**Date:** March 30, 2021  
**To:** Jeremy Johnston, Kittitas County Community Development  
**From:** Darin Yusi, Gas Engineer   
**Re:** Proposed Bull Ranch Development Project

The following are the City of Ellensburg Gas Division comments on the proposed Bull Ranch Development off Bull Rd and Kittitas Hwy.

CITY OF ELLENSBURG NATURAL GAS DIVISION UTILITY MAP REQUEST INFORMATION

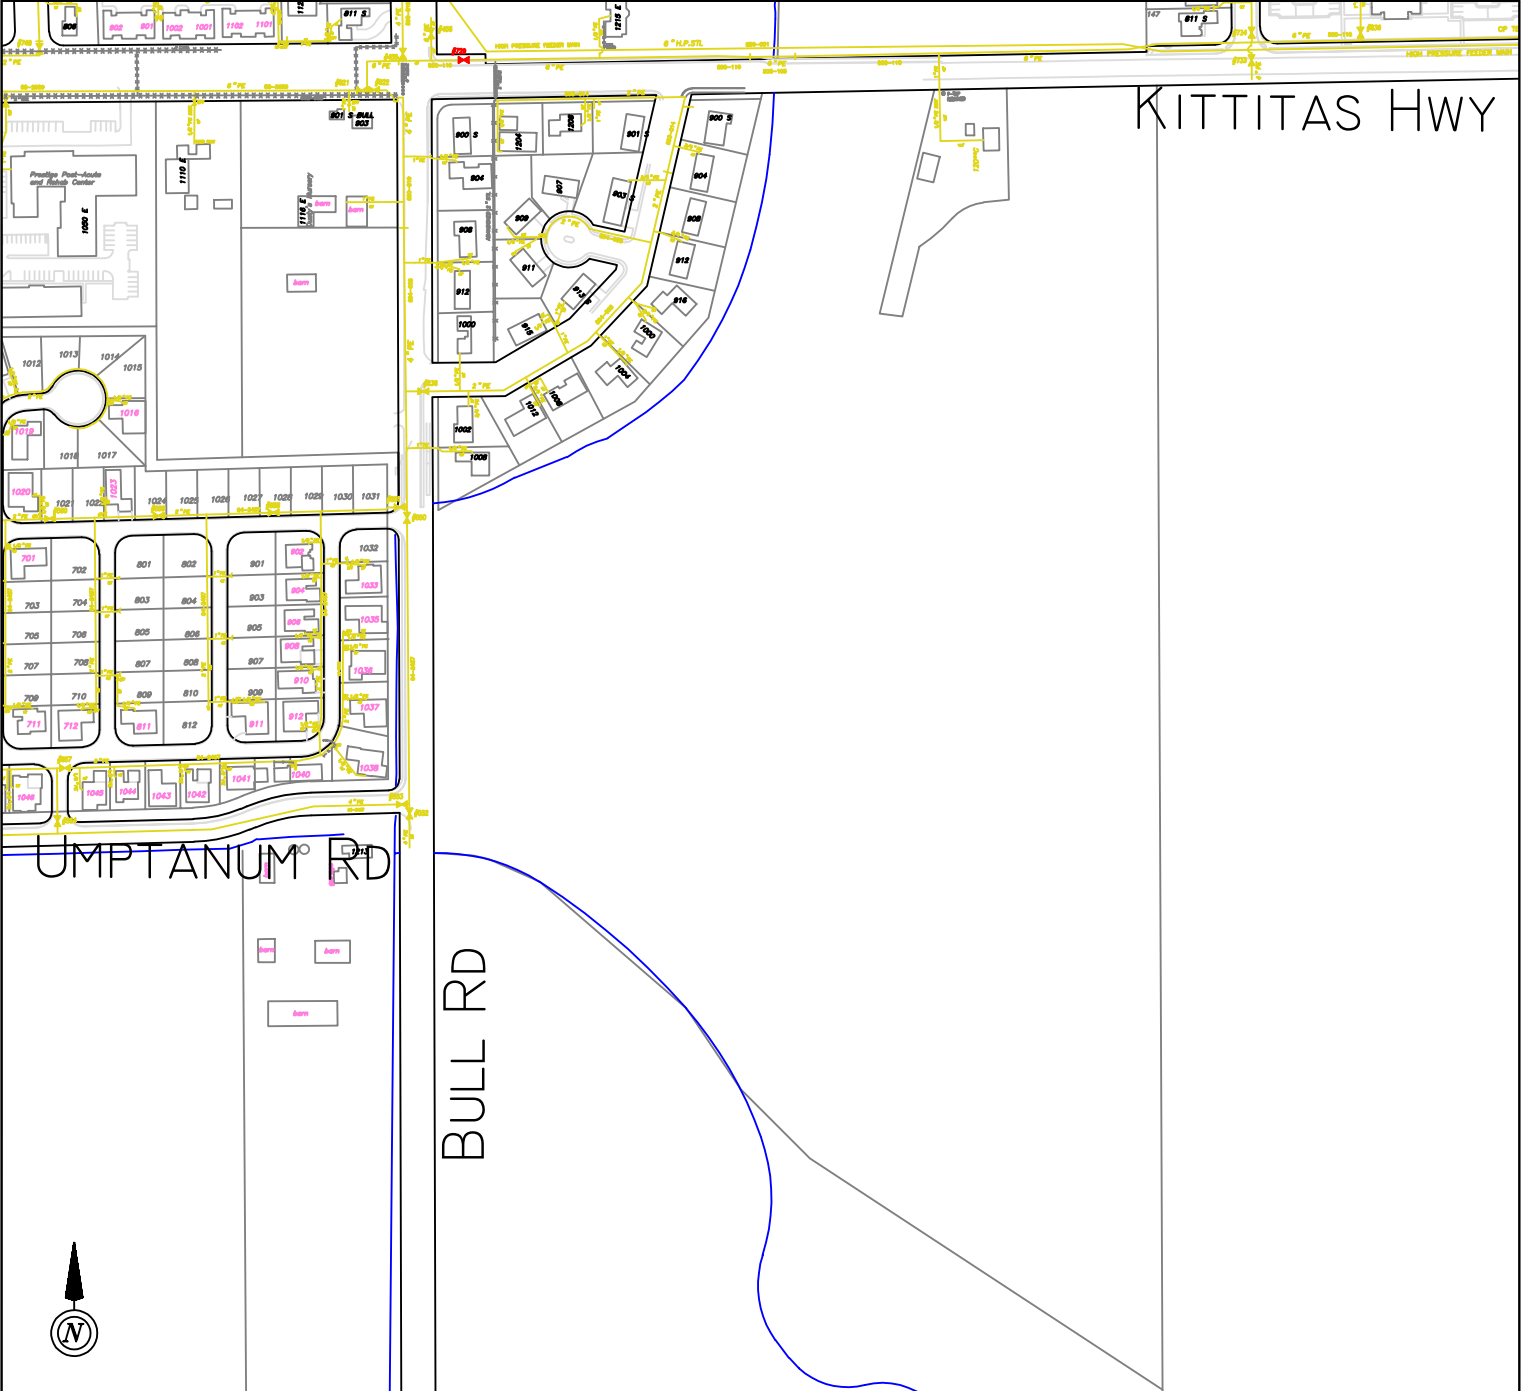
There is a 4-inch main located at the intersection of Bull Rd and Umptanum Rd. The City of Ellensburg Bull Road Utility Extension project currently under construction will include the extension of that 4-inch main across Bull Road to the entrance of the proposed development. This extension should take place by mid-year 2021.

The proposed development will be required to tie into the main on Bull Road and extend the gas main throughout the development and provide service stubs to each lot. The mainline will also need to be looped into the 6-inch main on the North side of Kittitas Highway. The developer will need to provide the road crossing, appropriate traffic control, and roadway/sidewalk restoration. A natural gas utility map is included with these comments.

G-12

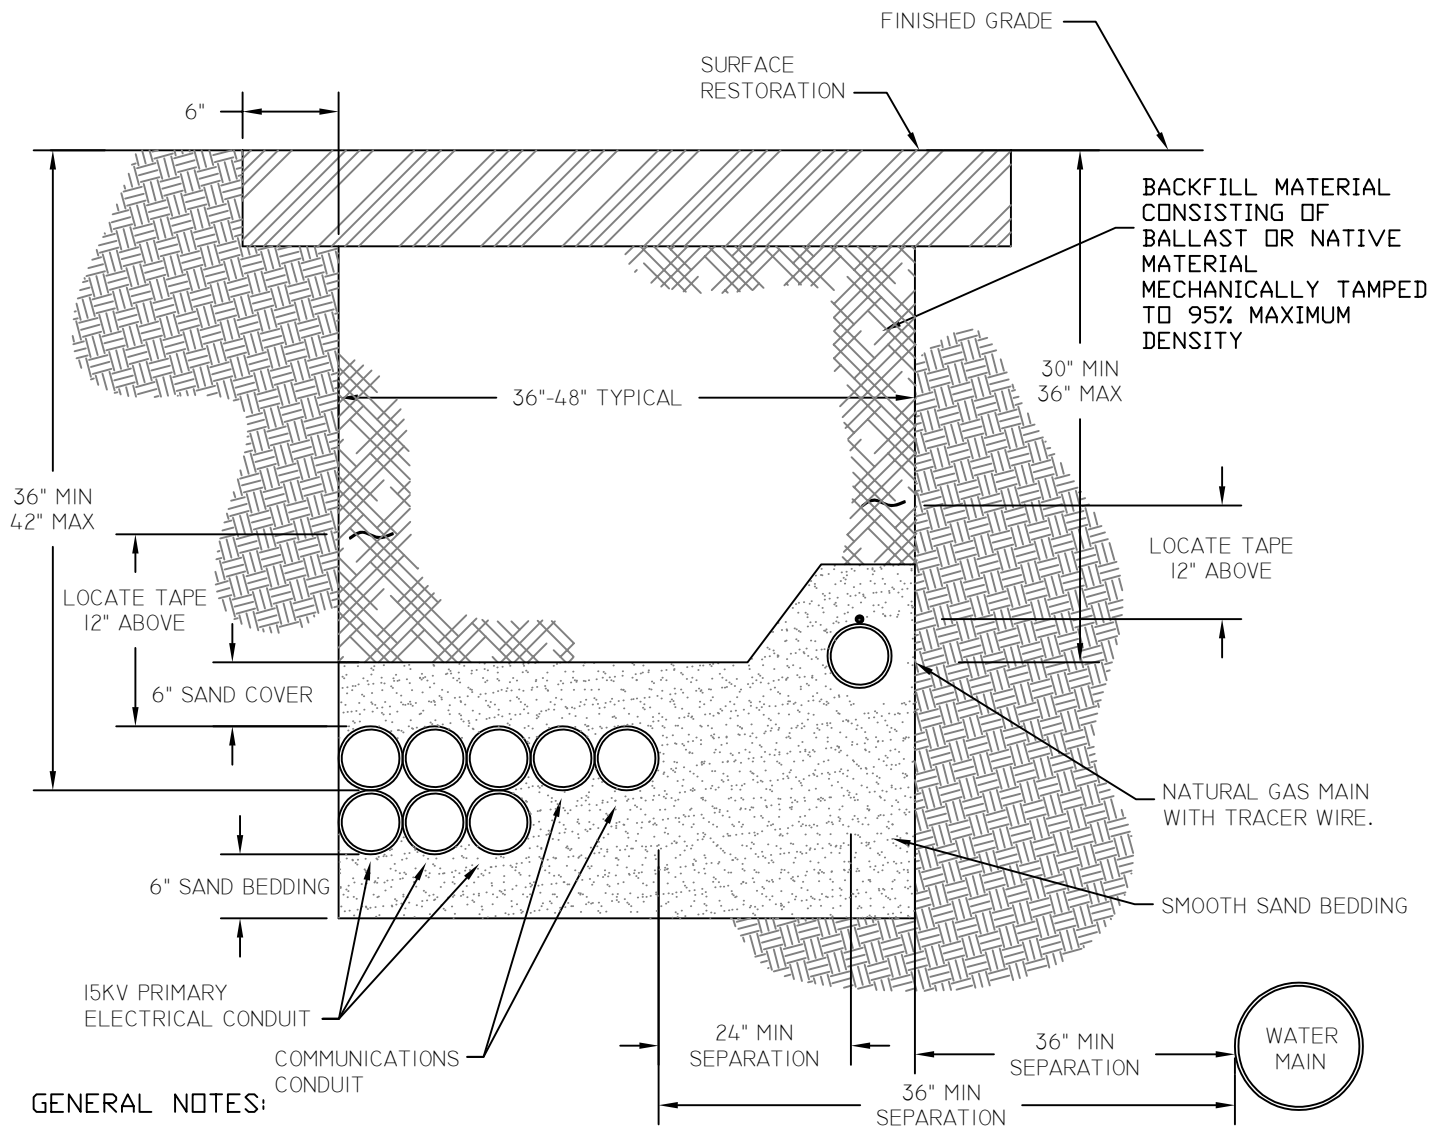
City gas crews will install gas main and service stubs in developer provided trenches. The applicant is to provide the trench, smooth sand bedding, and backfill at the specified depth and required utility separation as indicated on the details G-12 and G-13.
